PRELIMINARY/FINAL DRAINAGE REPORT

SOUTH ACADEMY BUSINESS CENTER

**Associated Design Professionals, Inc.
3520 Austin Bluffs Parkway, Suite 102
Colorado Springs, CO 80918
(719) 266-5212
Project No. 161103
5/6/20
PCD Project No 17-004**

FIGURE OS-2 TYPICAL OUTLET STRUCTURE
FOR FULL SPECTRUM DETENTION

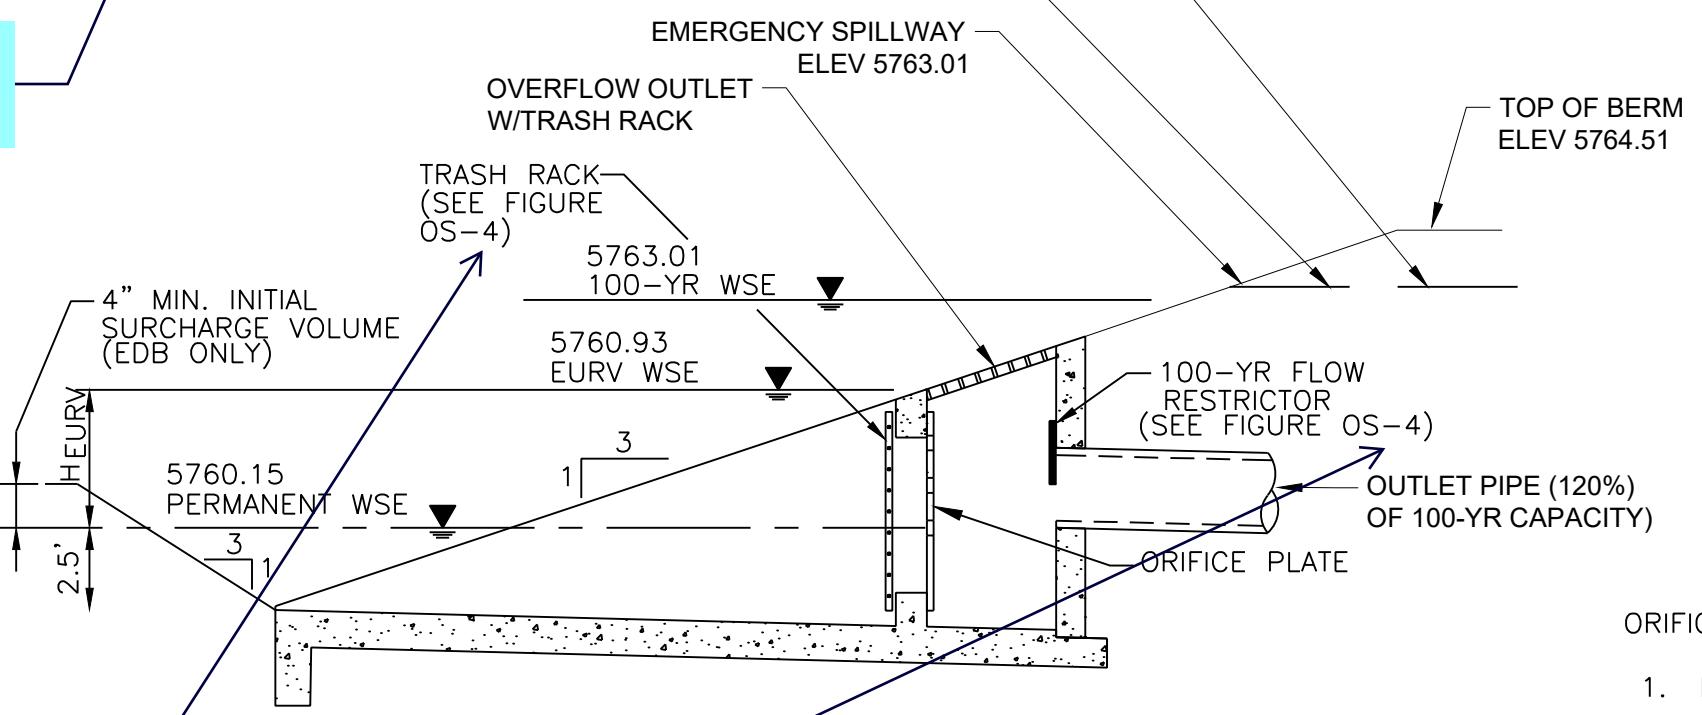
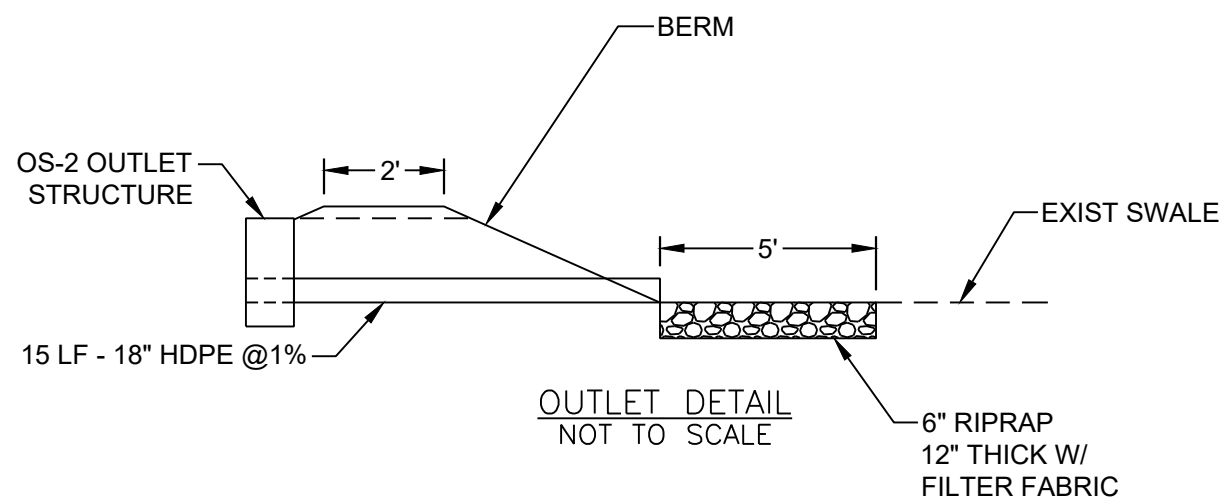
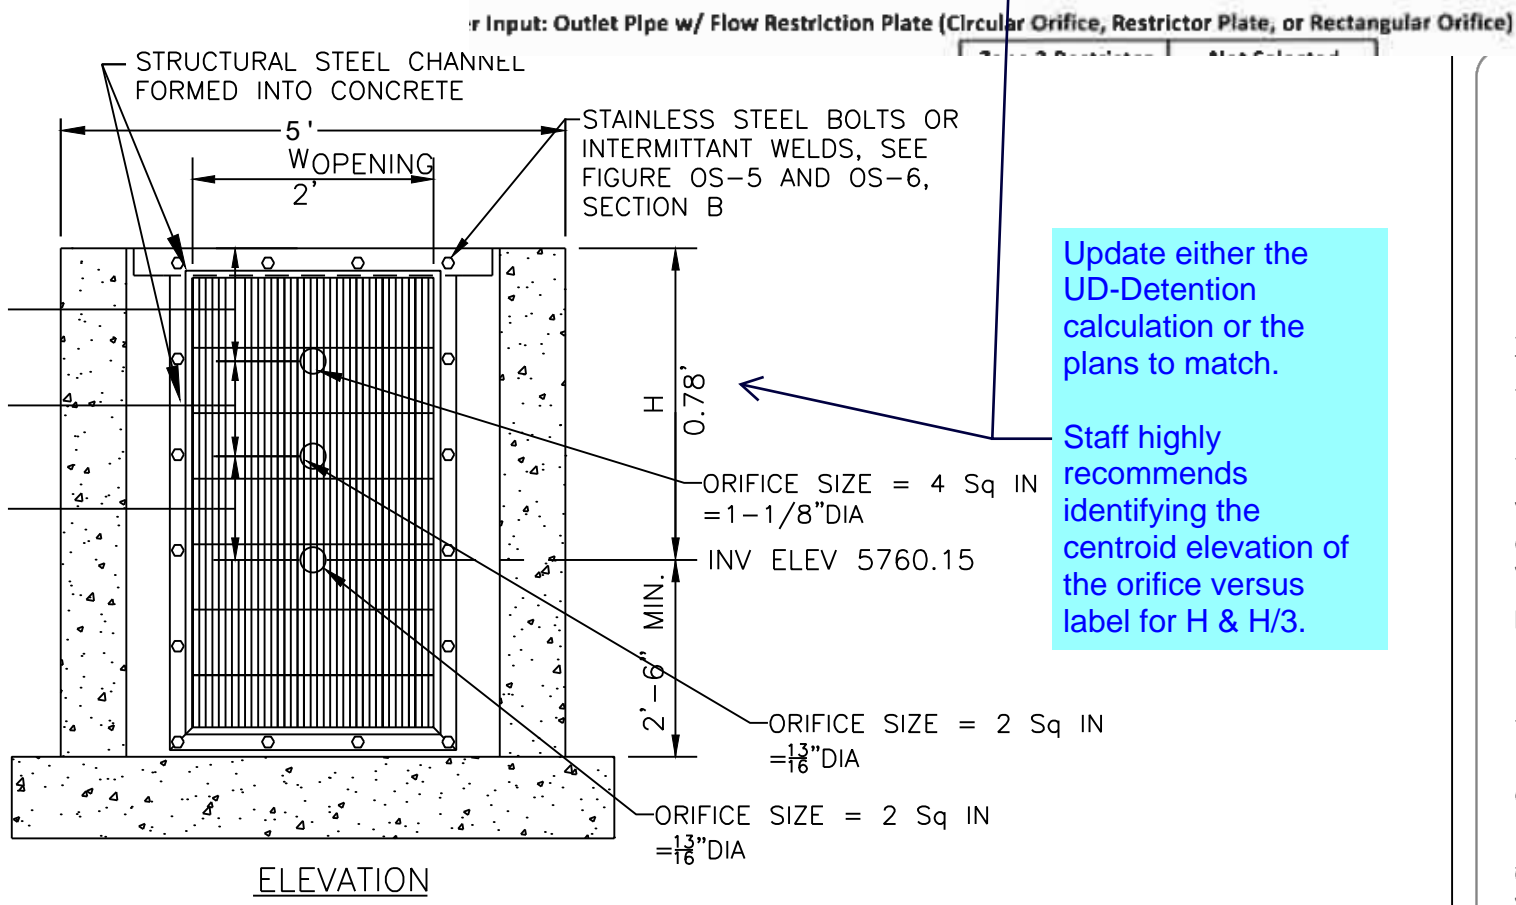
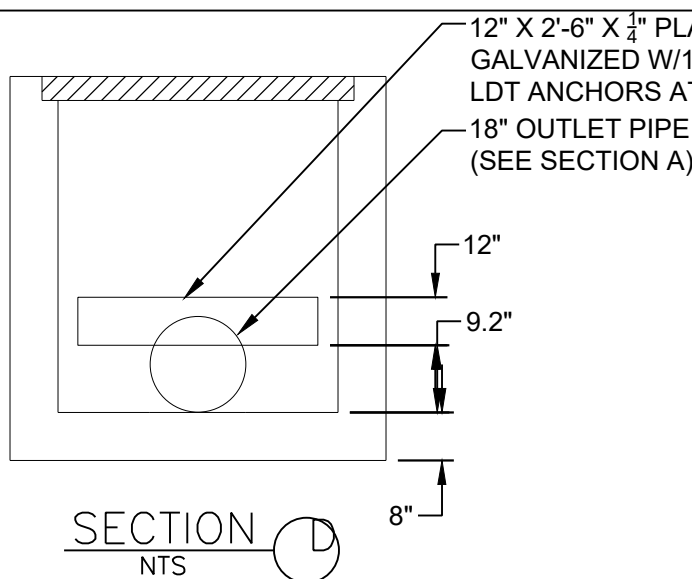
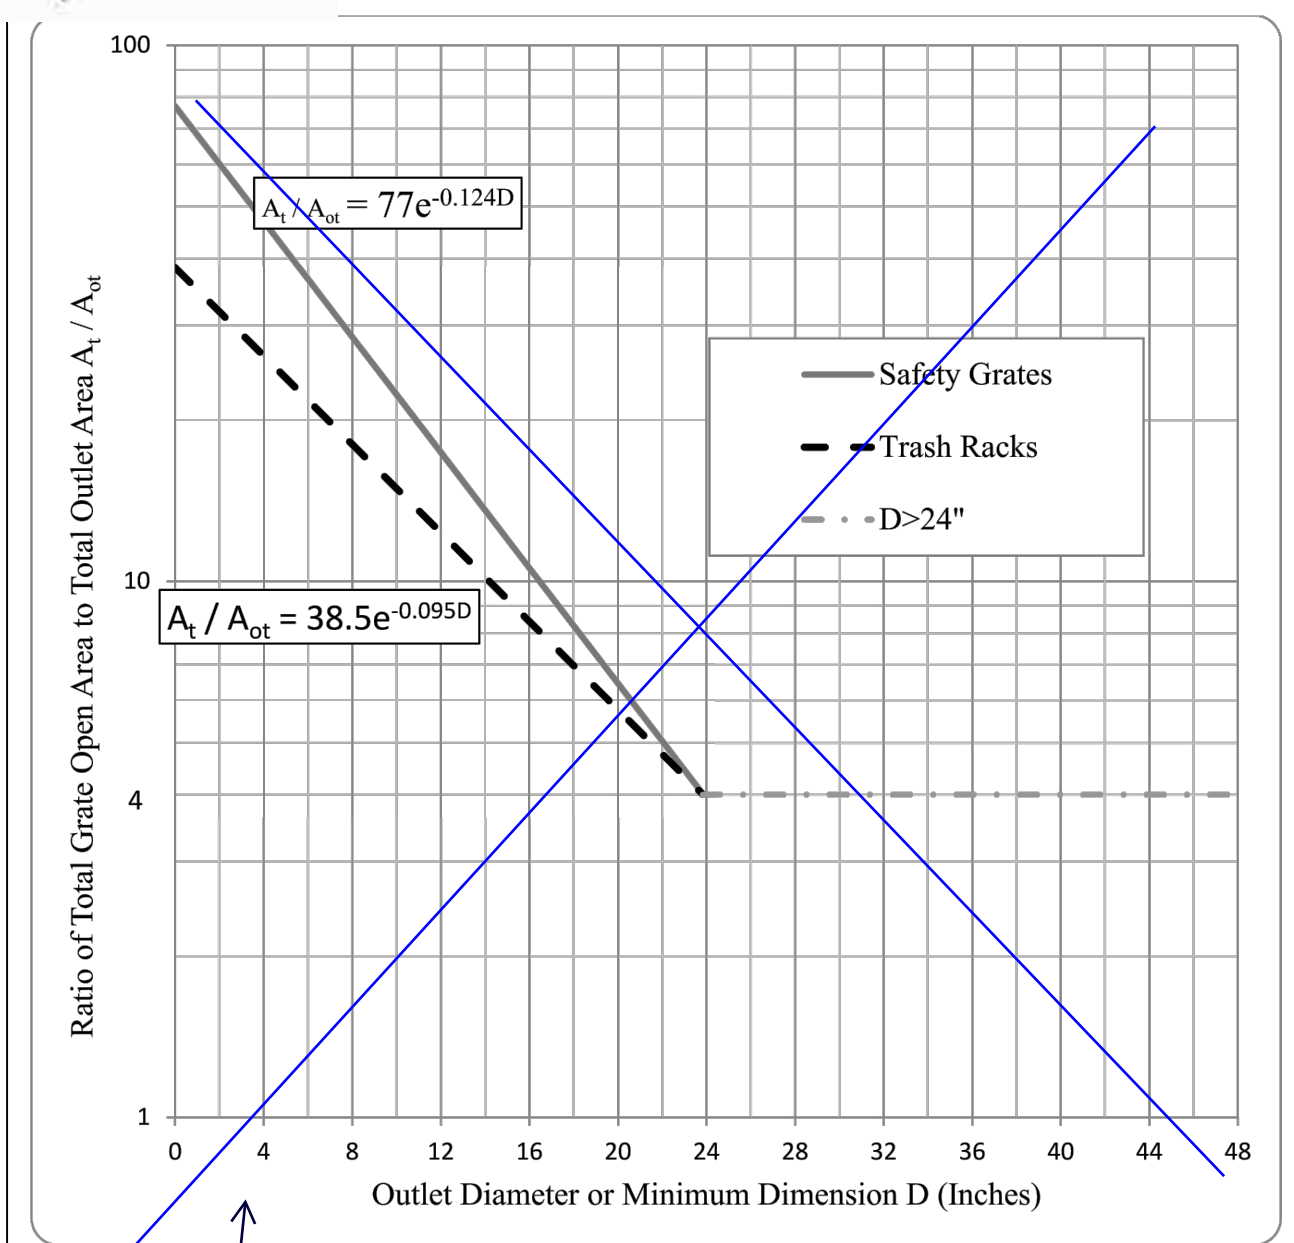
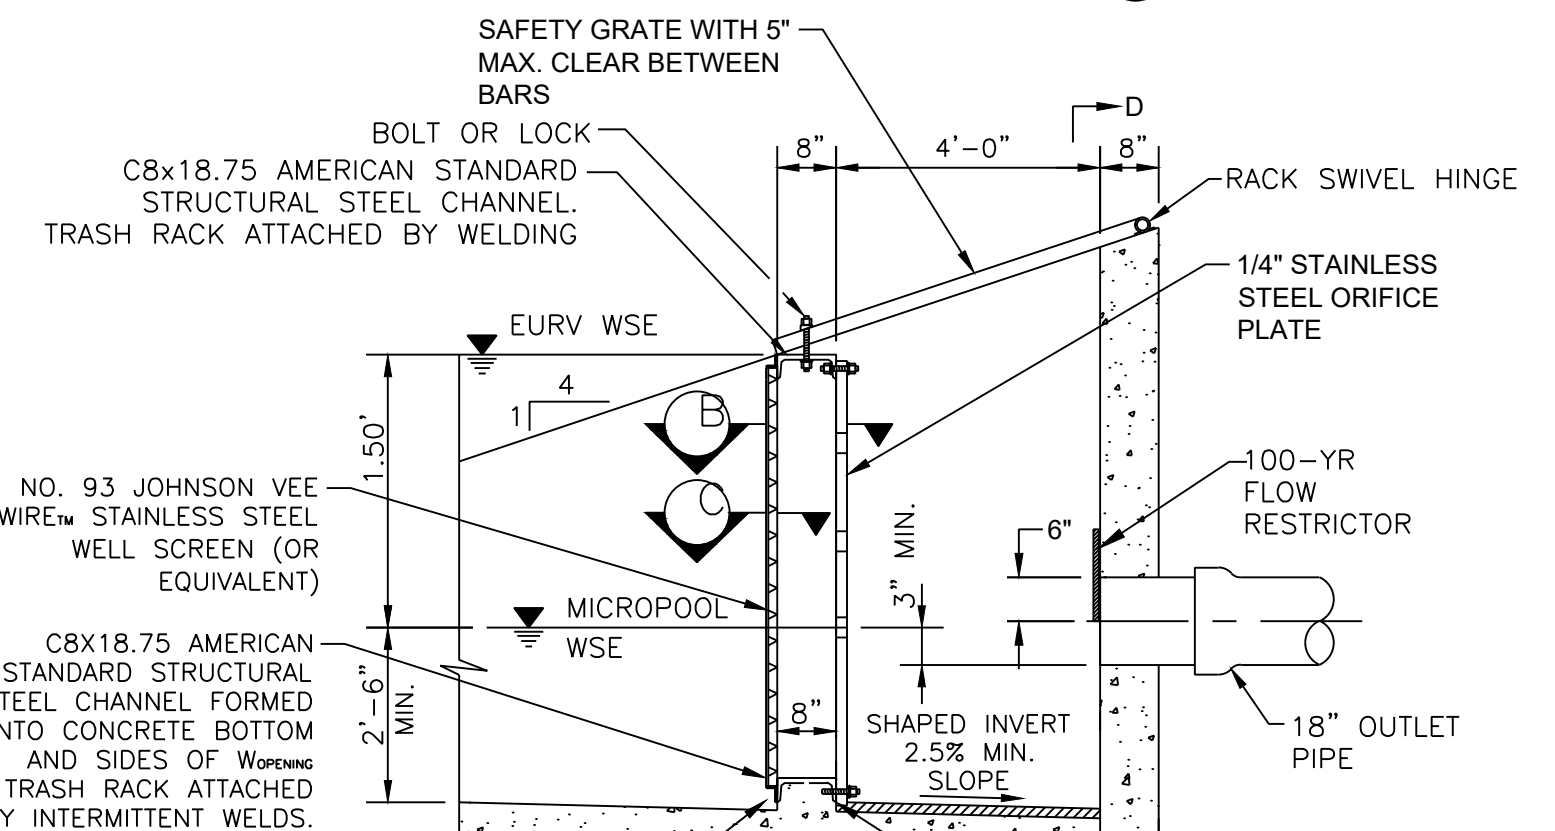
Revise. Incomplete sentence

Provide a copy of the railroad company's response.

Unresolved.
